Thank you for the review comments on the proposed Hay Creek Valley development (PCD File# SP-23-01). An avigation easement is currently being recorded and a final reception # will be available shortly. The following avigation notes have also been added to the cover sheet TS01 of the preliminary plan set.

Thank you for the opportunity to review the proposed Hay Creek Valley development: PCD File# SP-23-01 located adjacent to the United States Air Force Academy's (USAFA) northern boundary. After review, we offer the following comments.

TS01

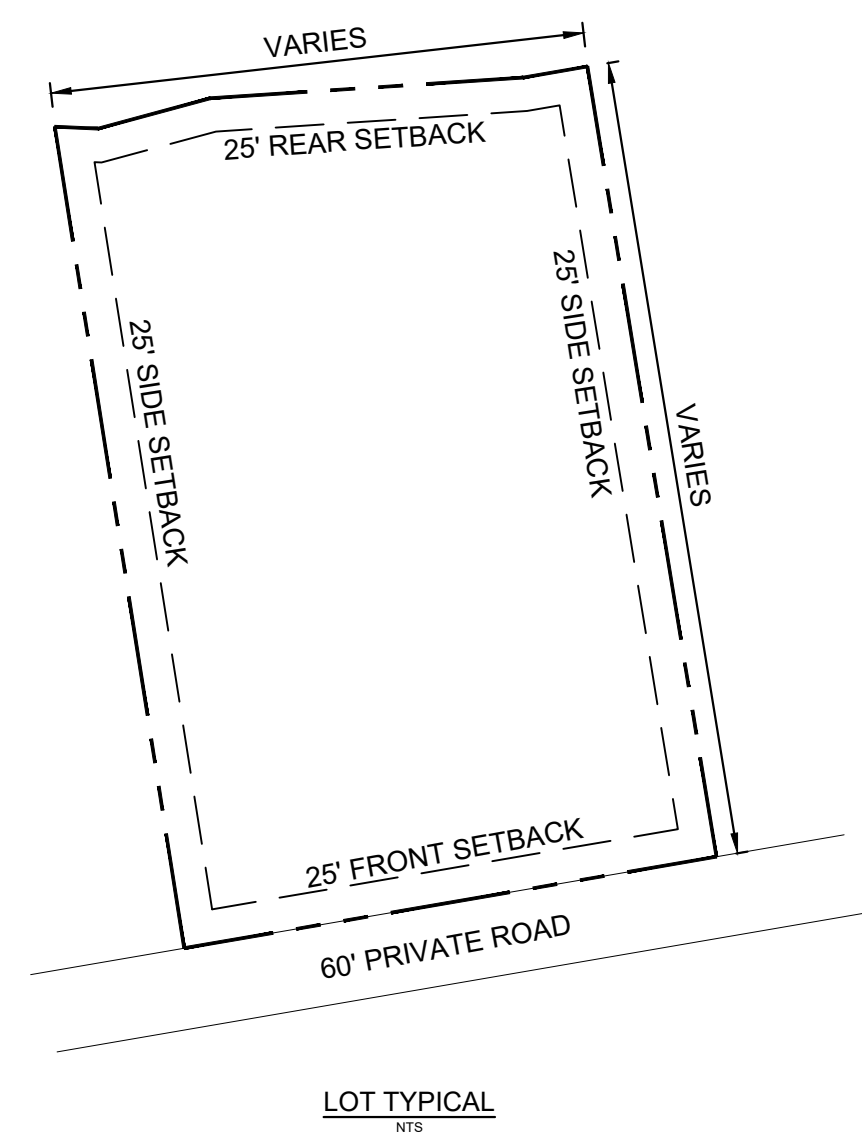
Therefore, USAFA asks the County to consider having the developer dedicate and record an aviation easement on the existing development site to help protect USAFA's flying mission from incompatible developments. This easement would acknowledge the right for the USAFA to conduct flight training in the area; we can provide a template to the assigned planner or applicant. When and if the aviation easement is recorded, please request the developer send a copy to the USAFA Community Planner's email addresses listed below.

USAFA also asks the County to request the developer include this note on the final property plat maps and covenants to provide full disclosure of nearby training operations at any future time of sale or lease:

Notice: This property may be impacted by noise and other similar sensory effects of United States Air Force (USAFA) land-based cadet training, small arms, and light weapons firing, and of flight caused by aircraft both in (USAFA's) Airmanship Program and during special events. This notice shall remain in effect until the Air Force Academy shall cease to be used for land-based and, flight training purposes, or until all training areas and airports on the Air Force Academy shall cease to be actively used. This notice shall run in perpetuity with the land.

1. An avigation easement effecting the subject property and development is subject to the terms and conditions as specified in the instrument recorded under reception no. _____ of the records of El Paso County, Colorado.
2. Notice: This property may be impacted by noise and other similar incidental sensory effects of flight caused by aircraft used in the united states air force academy's airmanship program. This shall remain in effect until the academy shall cease to be actively used. This notice shall run with the land.
